Subject: FW: Signage a AW/337/19/A installation of various signage, The Ship Inn, Aldwick Street.

I wish to object to the planning application AW/337/ 19/A .

PROPOSED SITE SIGNAGE

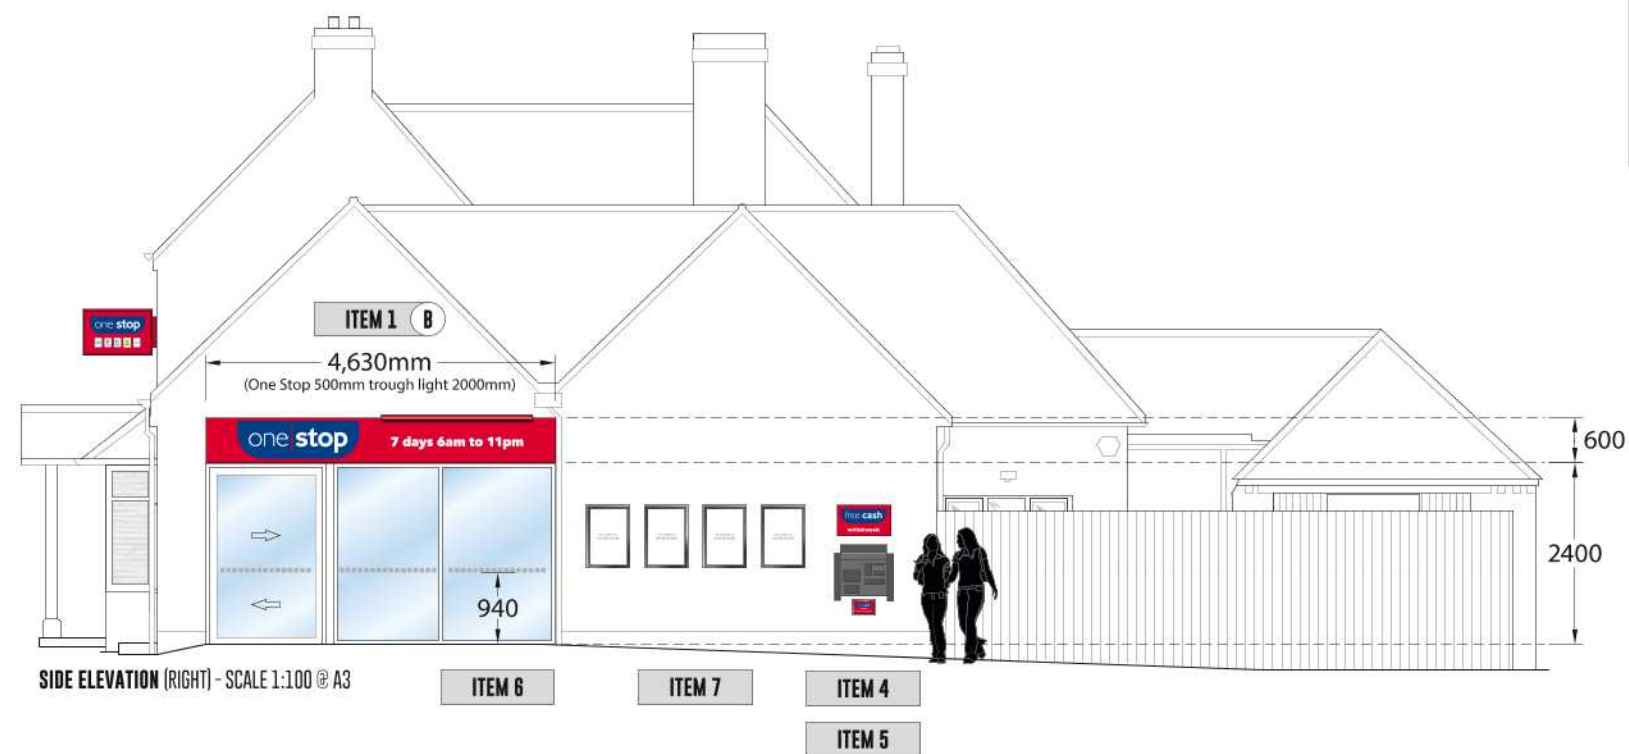
The planning application seeks to erect inappropriate signage on the Ship Inn pub building and site, designated with Arun DC as an Asset of Community Value. The building is also recognised as of "special character" but the signage and its garish livery will degrade the building. It is out of keeping with the surroundings and the accompanying lighting will pollute the environment in the hours of darkness. It will also be unfair for the local residents at night.

PROPOSED SITE SIGNAGE

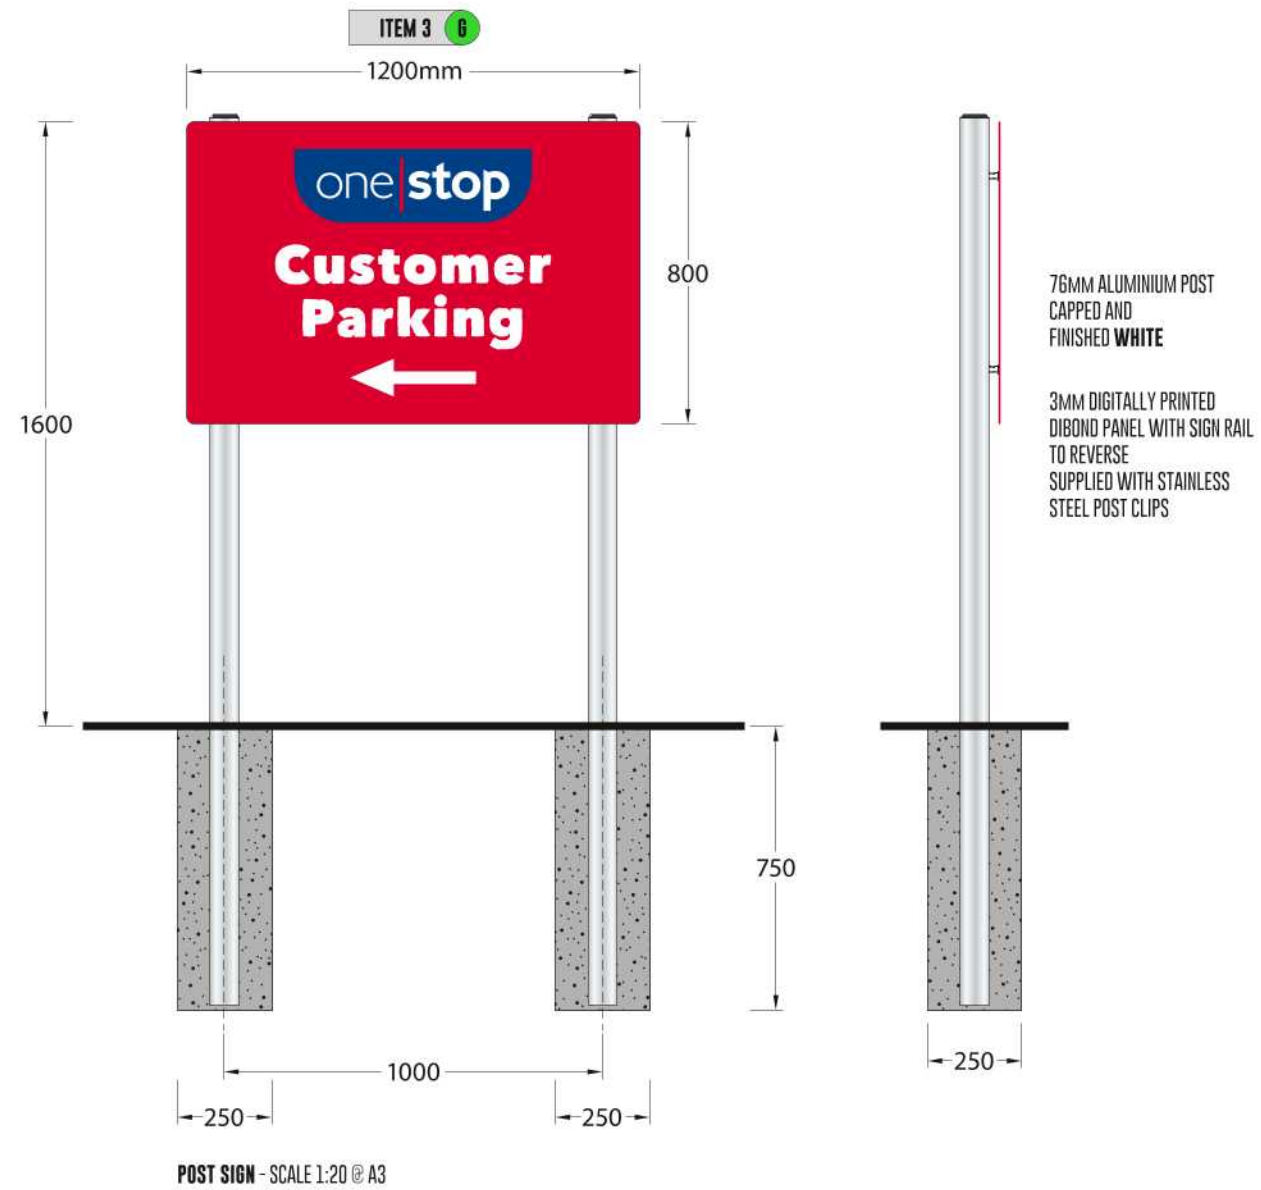
The proposed panels covering the bay windows disfigure the building and are out of character with the parade of shops on the other side of the road. There is also one extra panel proposed on the eastern end of the front elevation.
